Application Reference: P/107/25/DOC Site Name: Land West of Hook Lane Pagham PO21 3PB	Initial Issue Date: 12/12/2025 Issue Date: 12/12/2025 Reviewer Reference: ADC/EXT4
--	--

Summary and Recommendation:

Condition 9: **Further information required**

CS&P Drawing – Proposed Formation levels

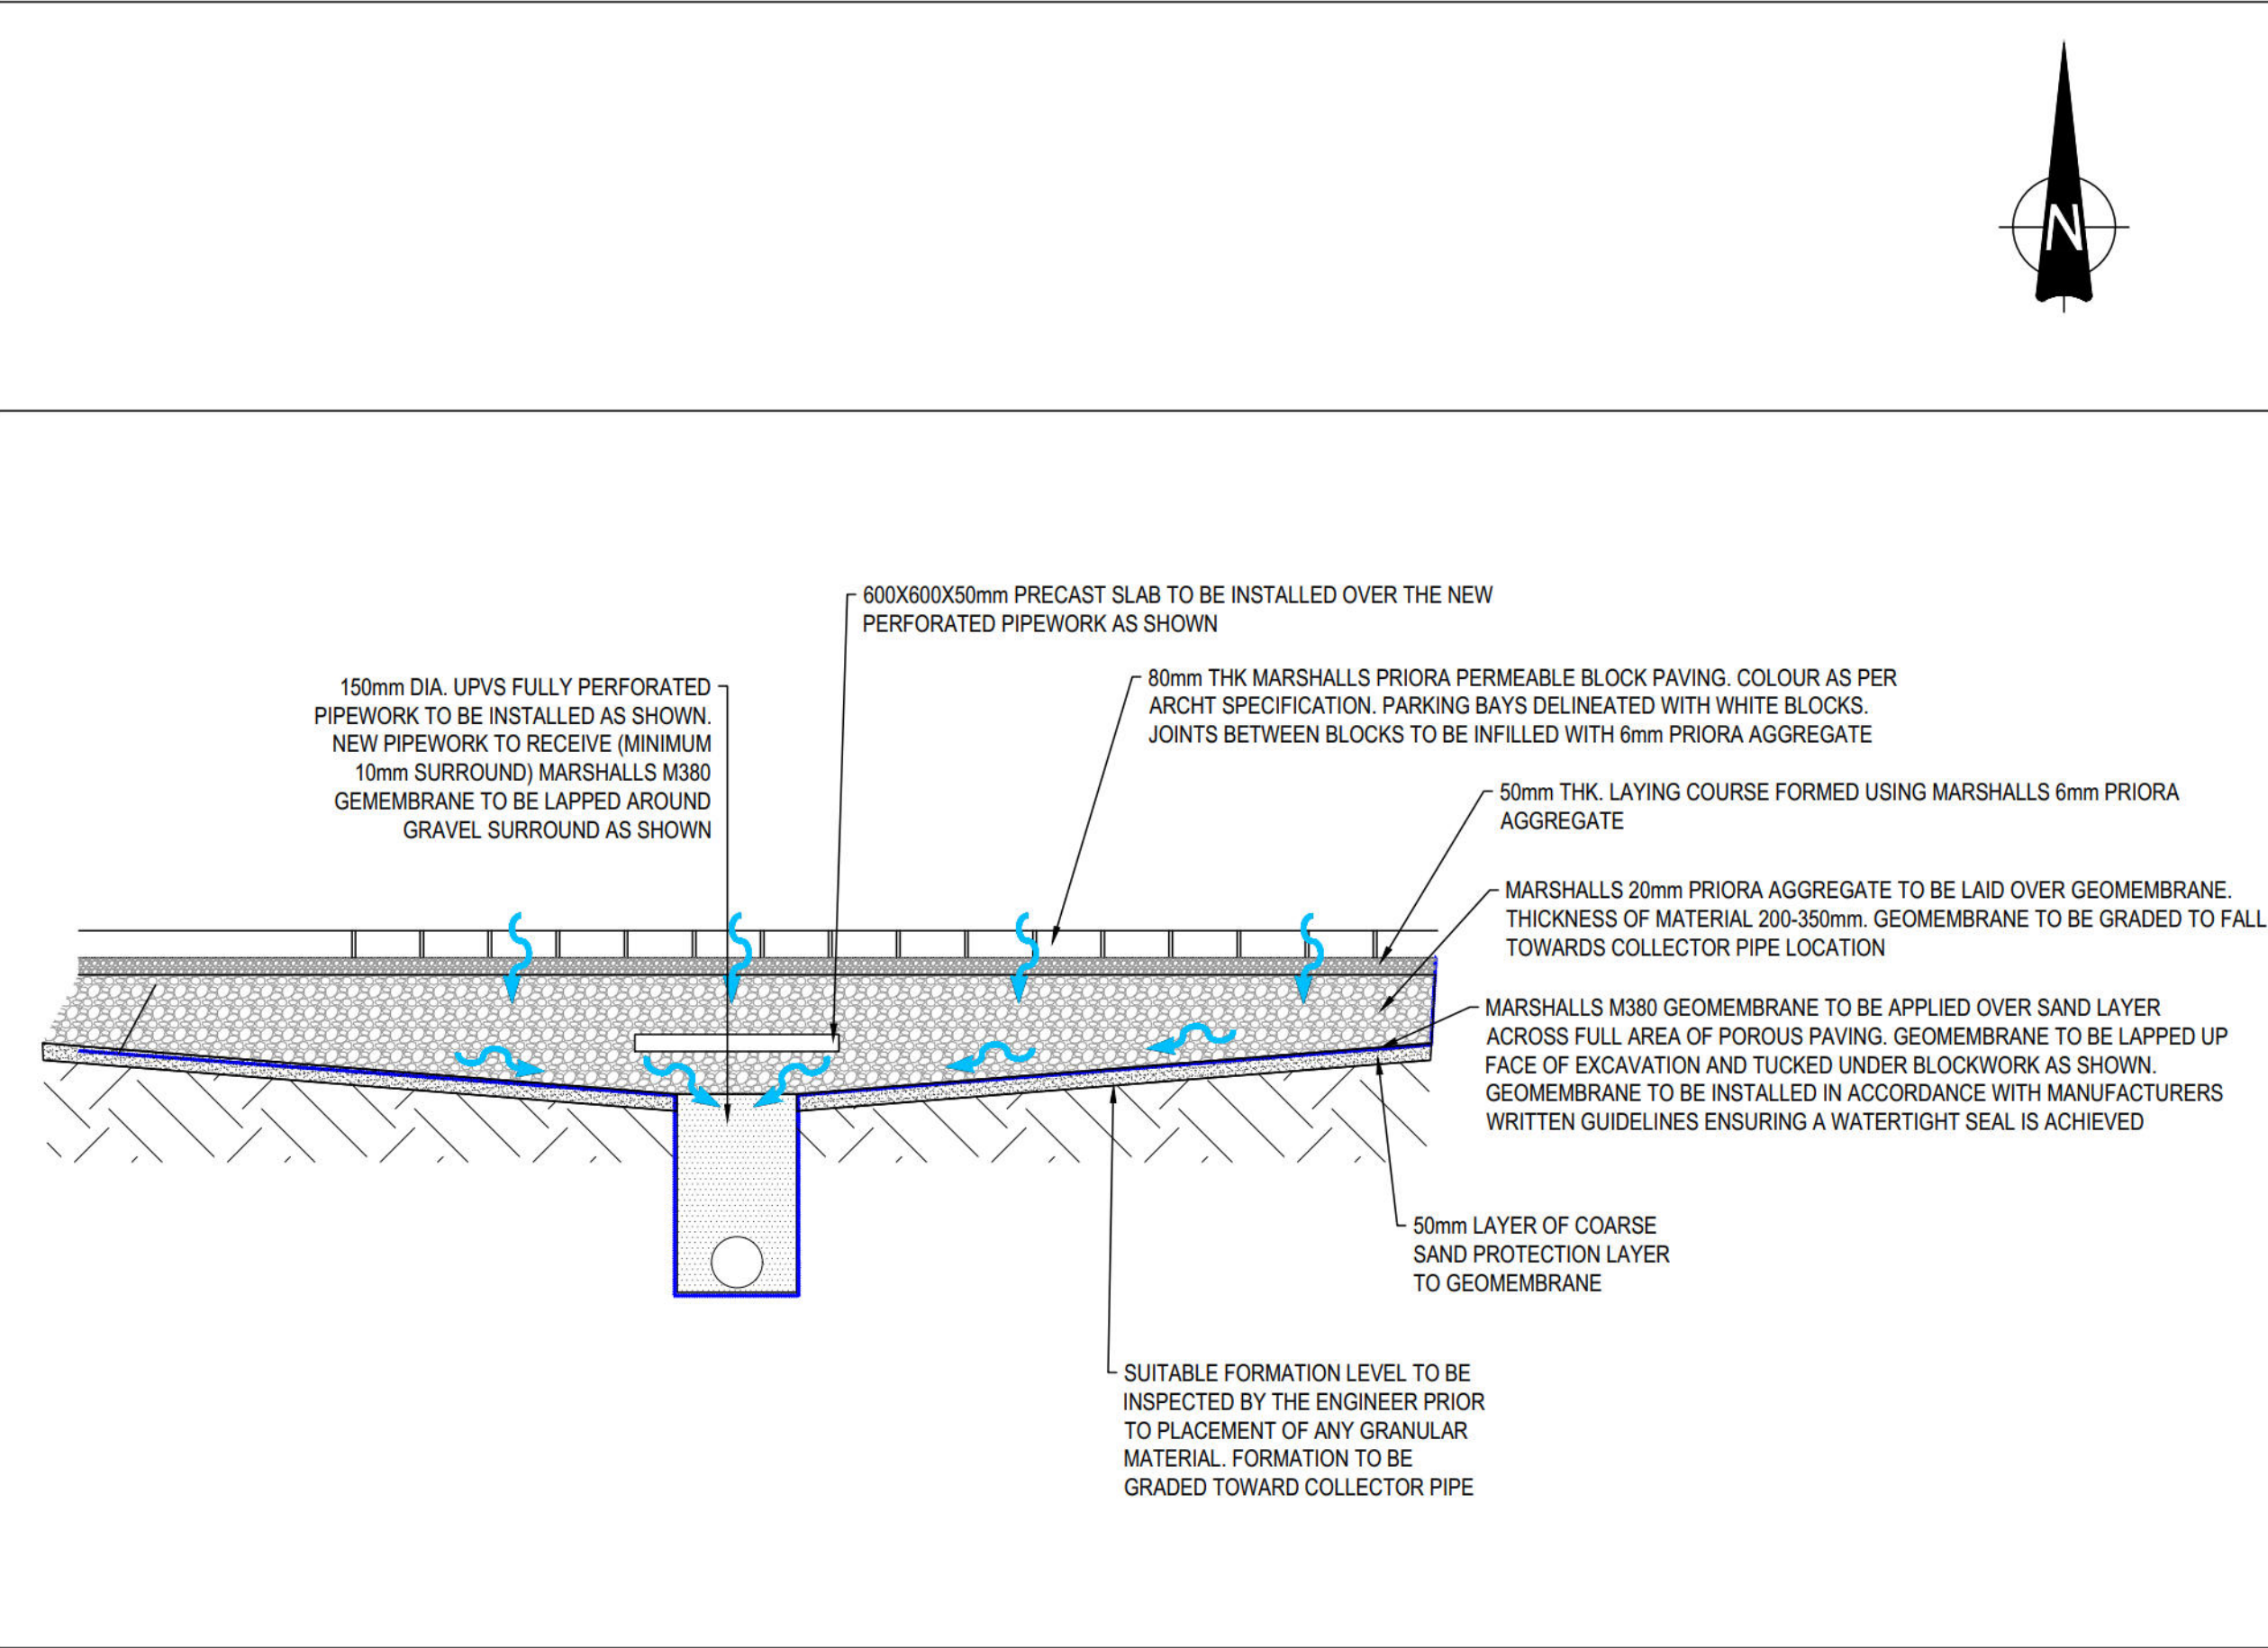
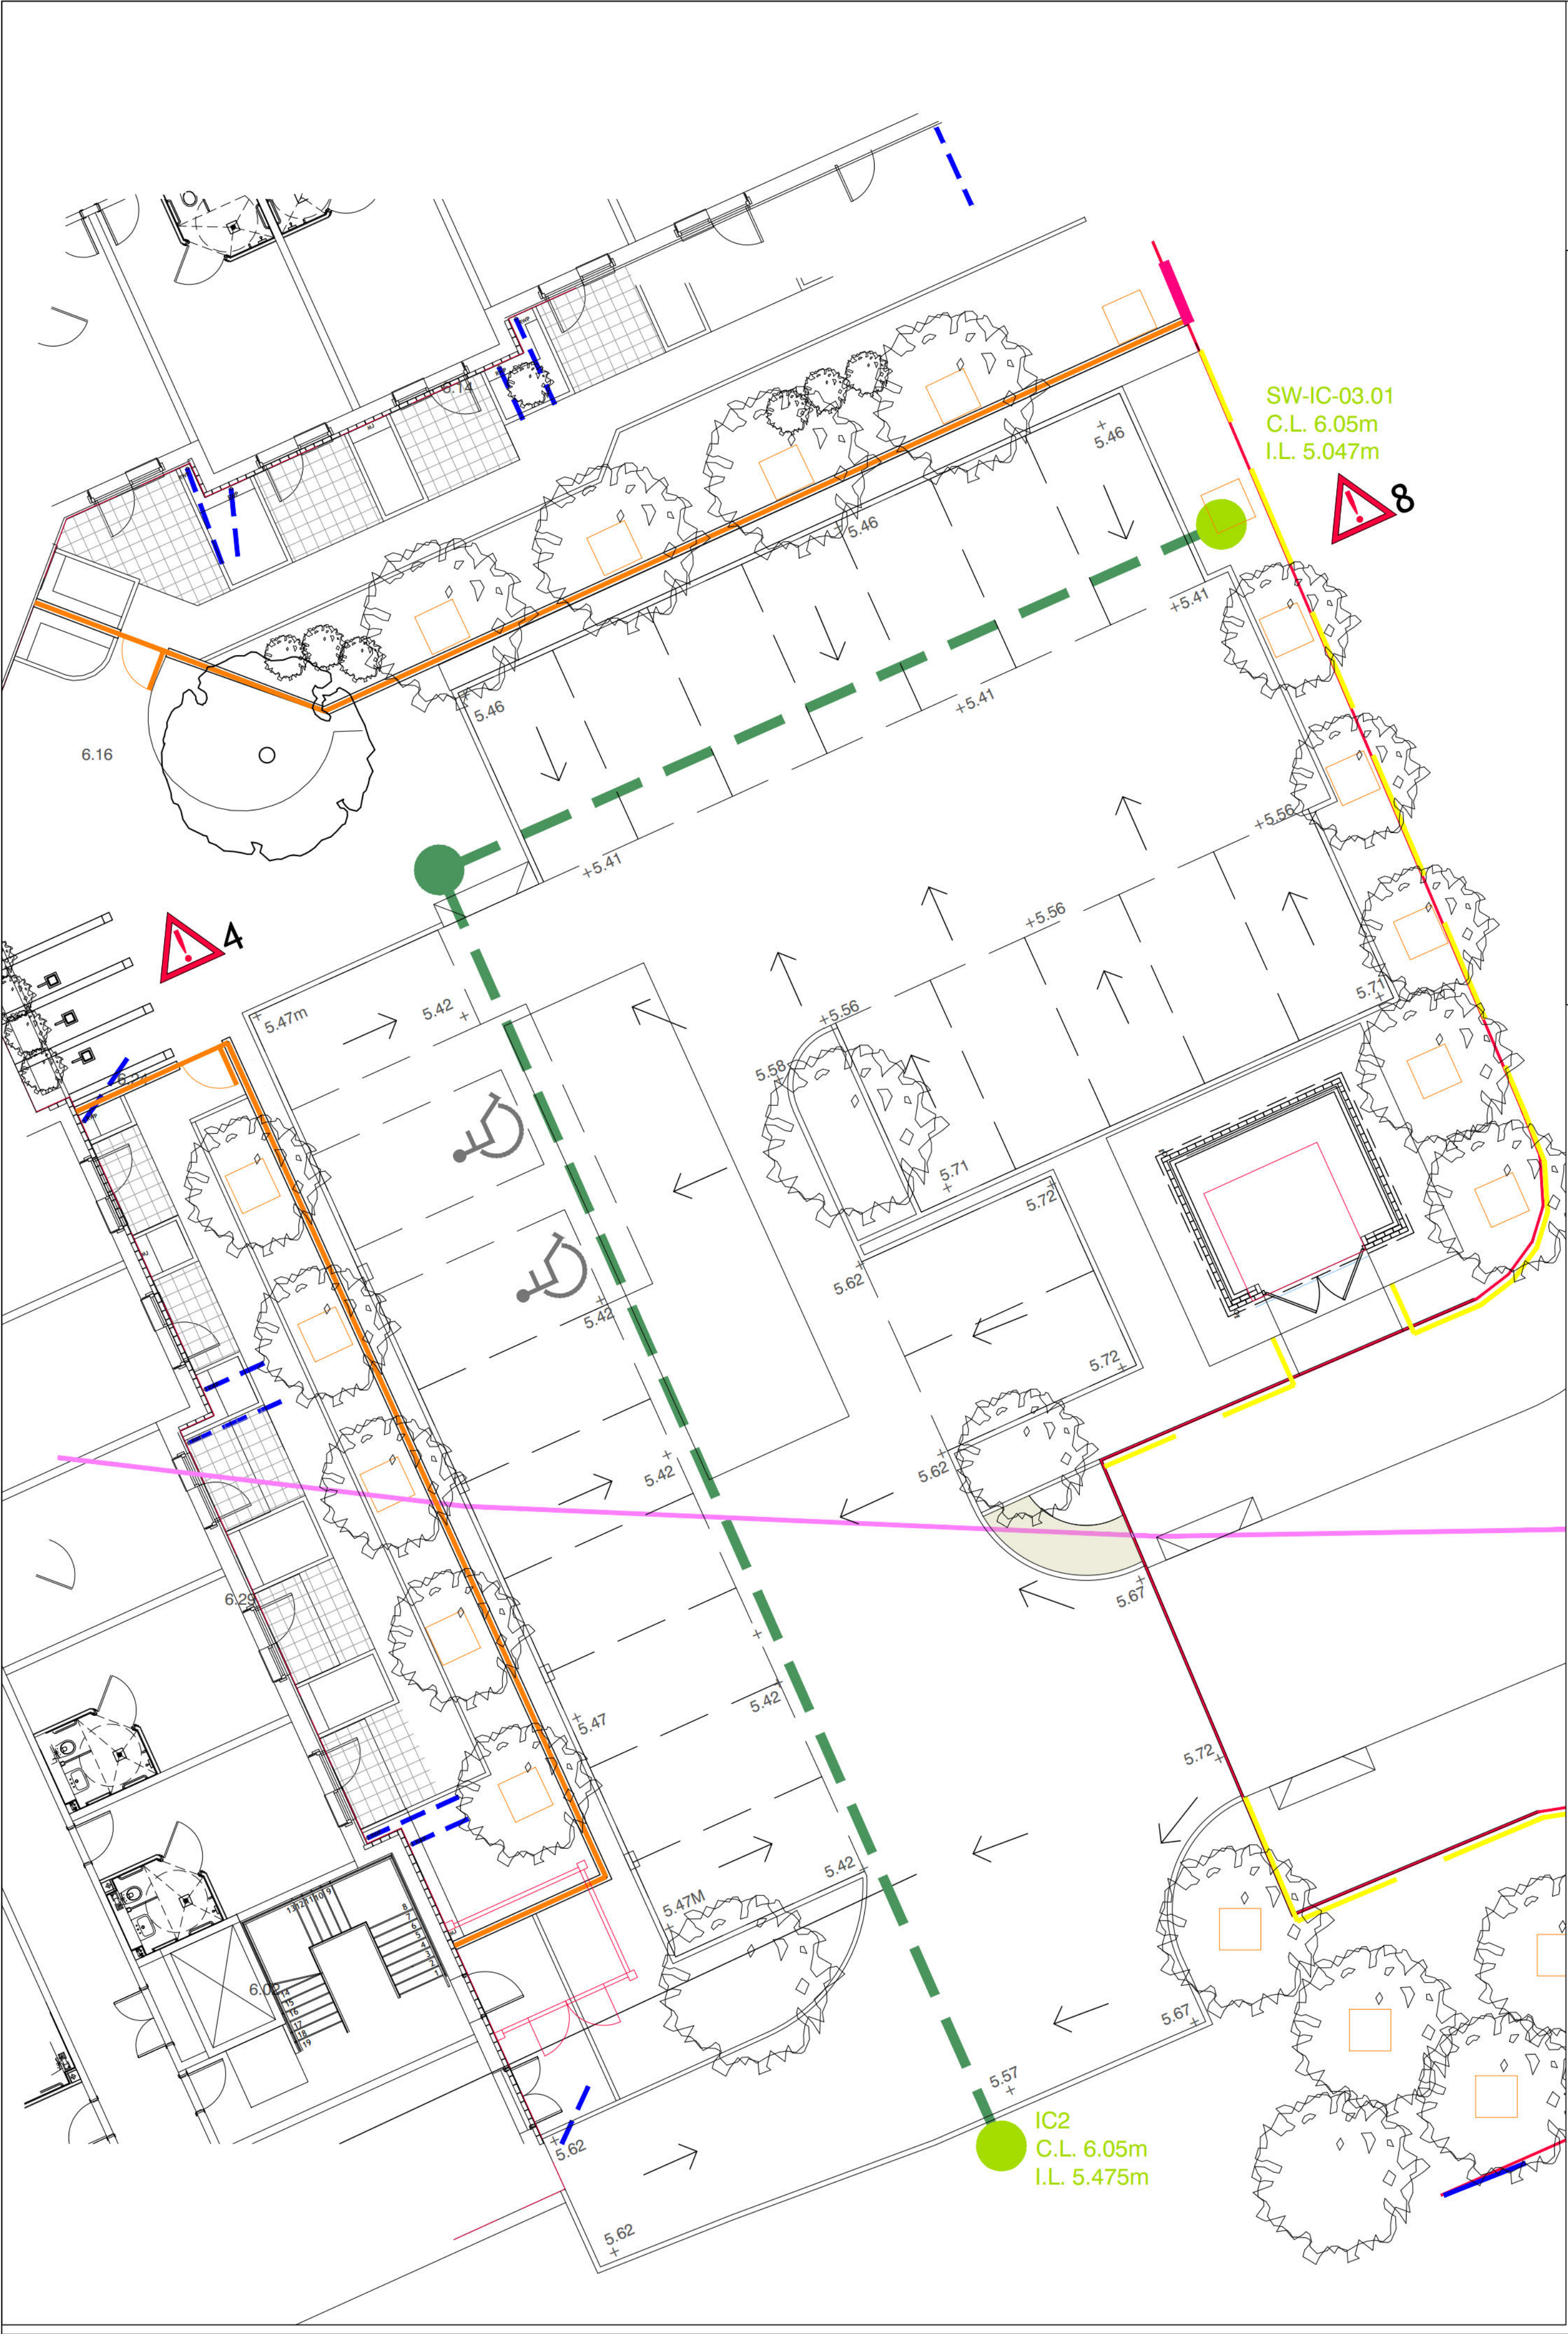
areas of paving around the buildings where levels have not been shown or are sparse. Please demonstrate that there are adequate falls for these areas to be drained as intended. The manhole cover levels on the drainage drawing suggest some of these areas are flat B) Levels of the formation of the permeable paving must be provided	A. See Rev. C Calculations - Updated Drawings & Calculations. B. The minimum thickness of subbase is 300mm thick and is graded out to low points. Contractor will install pipes accordingly to suit services.			
--	--	---	--	--	--
